ENG-EGP22006-R1-GEC.pdf Markup Summary

Subject: Stormwater Comments Color
Page Index: 1
Date: 3/14/2023 4:42:40 PM
Author: dotprete
Color: ■
Layer:
Space:
Page Label: [1] 1 2514207CV02 - CV01

Table VT-1

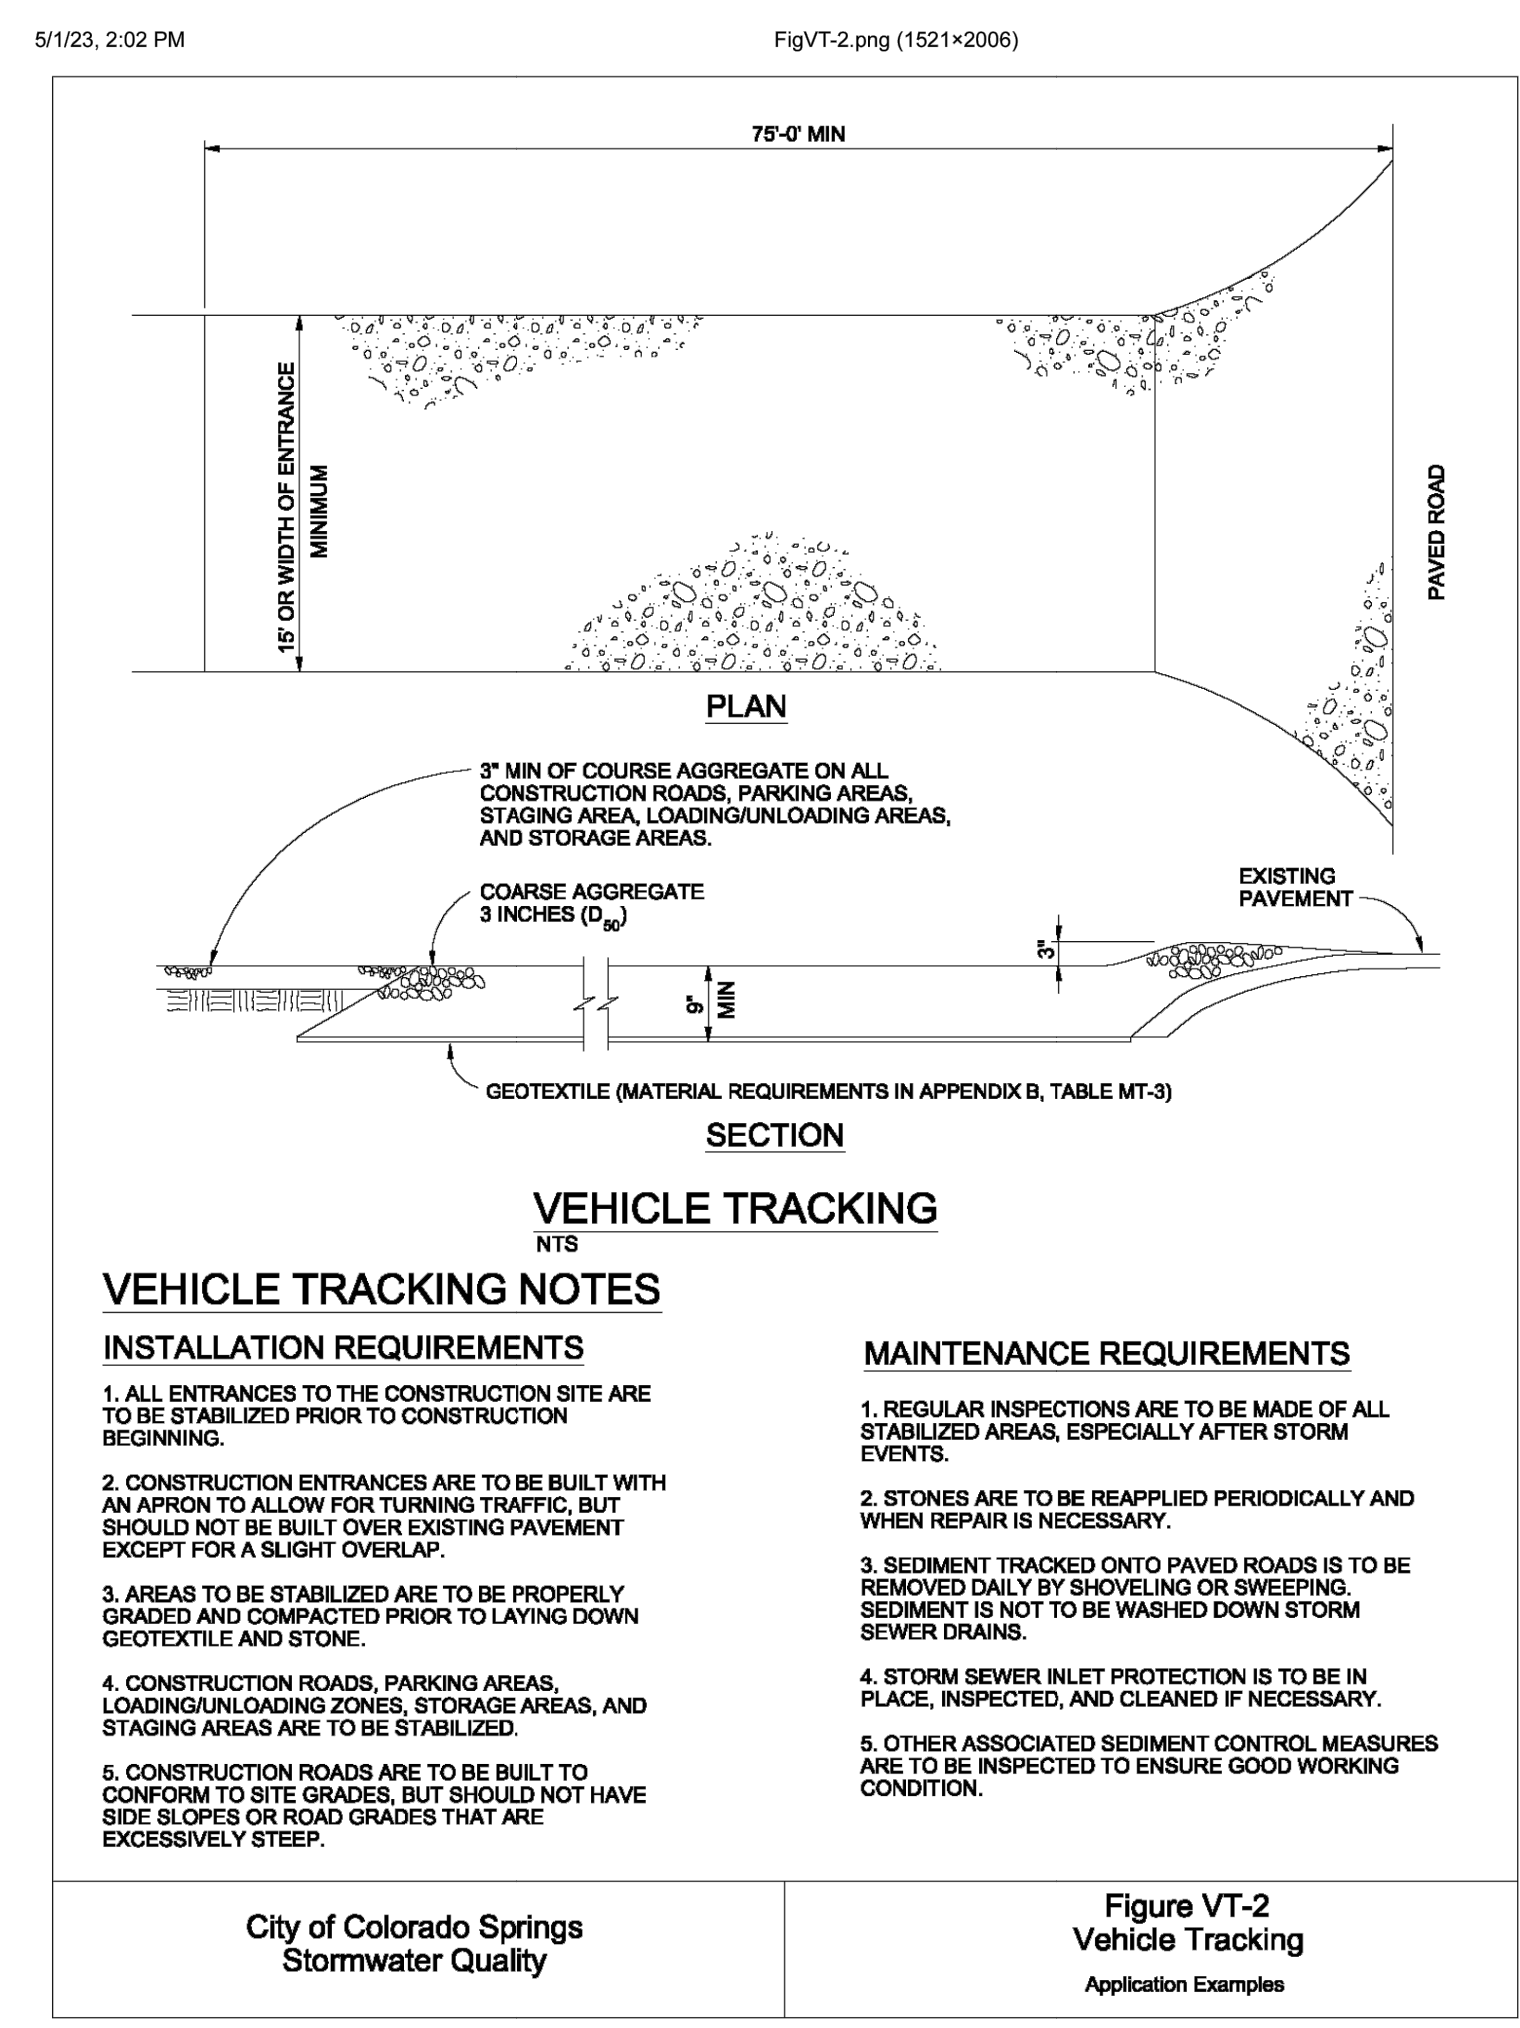
Replace with EPC approved VTC detail (VT-1 and VT-2 in DCMv2, Chap 3.3) or revise to be 75ft min length.
